Response by Michael Brown (IP ref. [REDACTED]) to the SoS's letter dated 4th September 2026
inviting comments from Interested Parties on the Late Response by the Applicant

Outline Residential and Visual Amenity Plan – July 2026 (C1-108)

APPENDIX A | LANDSCAPE PARAMETER PLAN

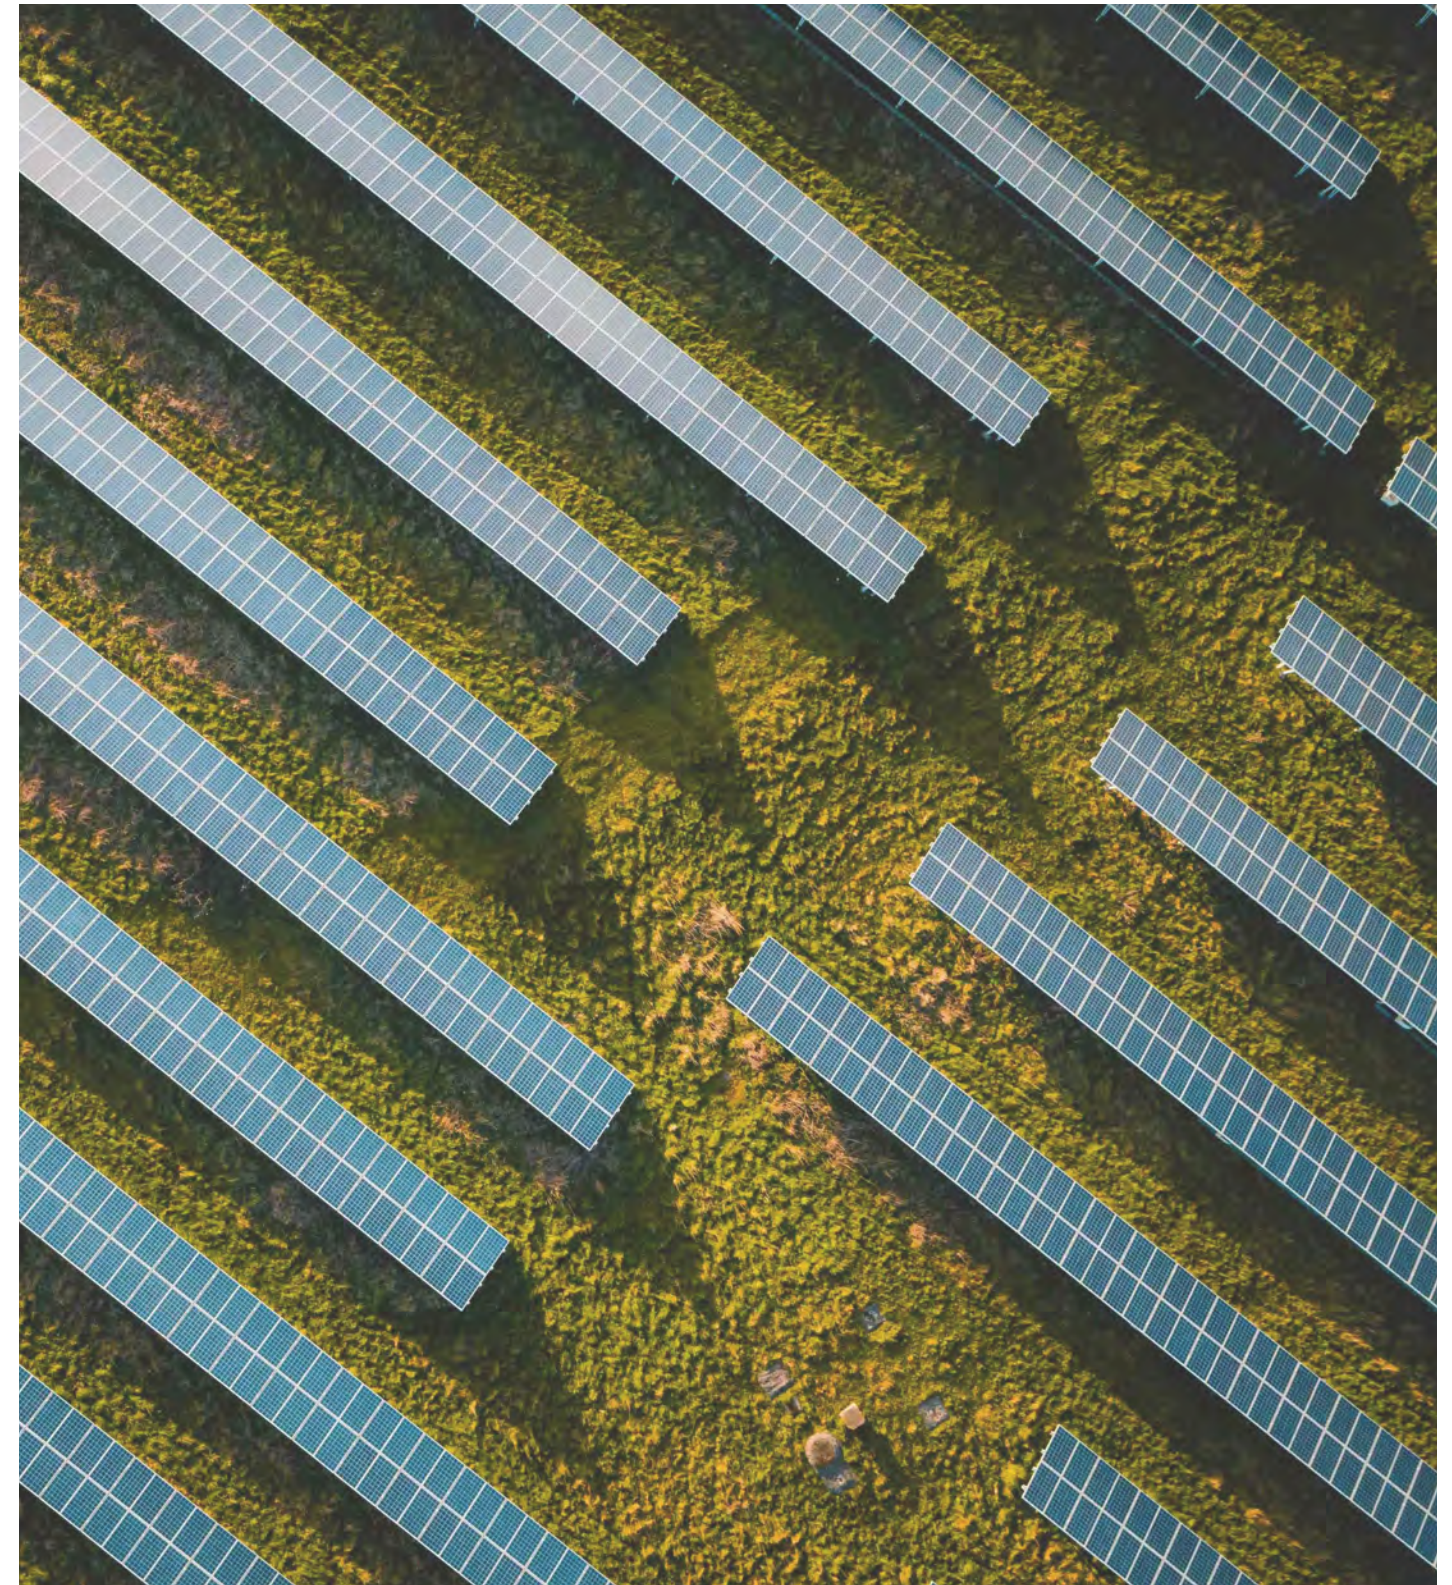
22. Ignoring the reference to field work and site specific design, this explanation in the Cover Letter is difficult to follow. There seems to be an assumption that the Landscape Parameter Plan (Appendix A to the oRVAP) is a ‘done deal’ and that therefore everything based on it must be OK. This is certainly not the case. As the Applicants’ letter indicates the Parameter plan is used as the basis for the oRVAP, which in turn they say *‘secures the embedded mitigation necessary to avoid and minimise impact on residents visual amenity.’* I assume that ‘embedded mitigation’ is shorthand for the basic buffer of 100m offered to every relevant property within 250m, or perhaps it is also the 109m in the Judgement column in the table or the 130m mentioned in the text of the Submission Masterplan Assessment in the context of our home. (Page 43 of the oRVAP)

23. Whichever of these distances applies it will not *‘avoid’ or ‘minimise the impact on our visual amenity’*. The Parameter plan and the Rev5 Masterplan show a retrograde step from even the Rev. 4 Masterplan 2.2D (C1-051). Rev5 omits the longer distance upwards of 250m shown on the Rev 4 Masterplan. Further, the Parameter plan legend describes the grey areas by reference to the Works in Requirement 15 whereas the Rev 5 Masterplan legend describes the corresponding blue grey colour as being ‘Solar Panels and conservation Grazing Areas’.

garden walls. In the chart for Master Assessment no. 32 the 'judgement' is then stated to be only 109m. I have re-measured along the ground with a long tape measure the distance from our garden wall to the nearest point of panelling/works as shown on the Landscape Parameter Plan and the oRVAP. It is about 86m, not 100m as claimed nor 109m nor indeed 130m.
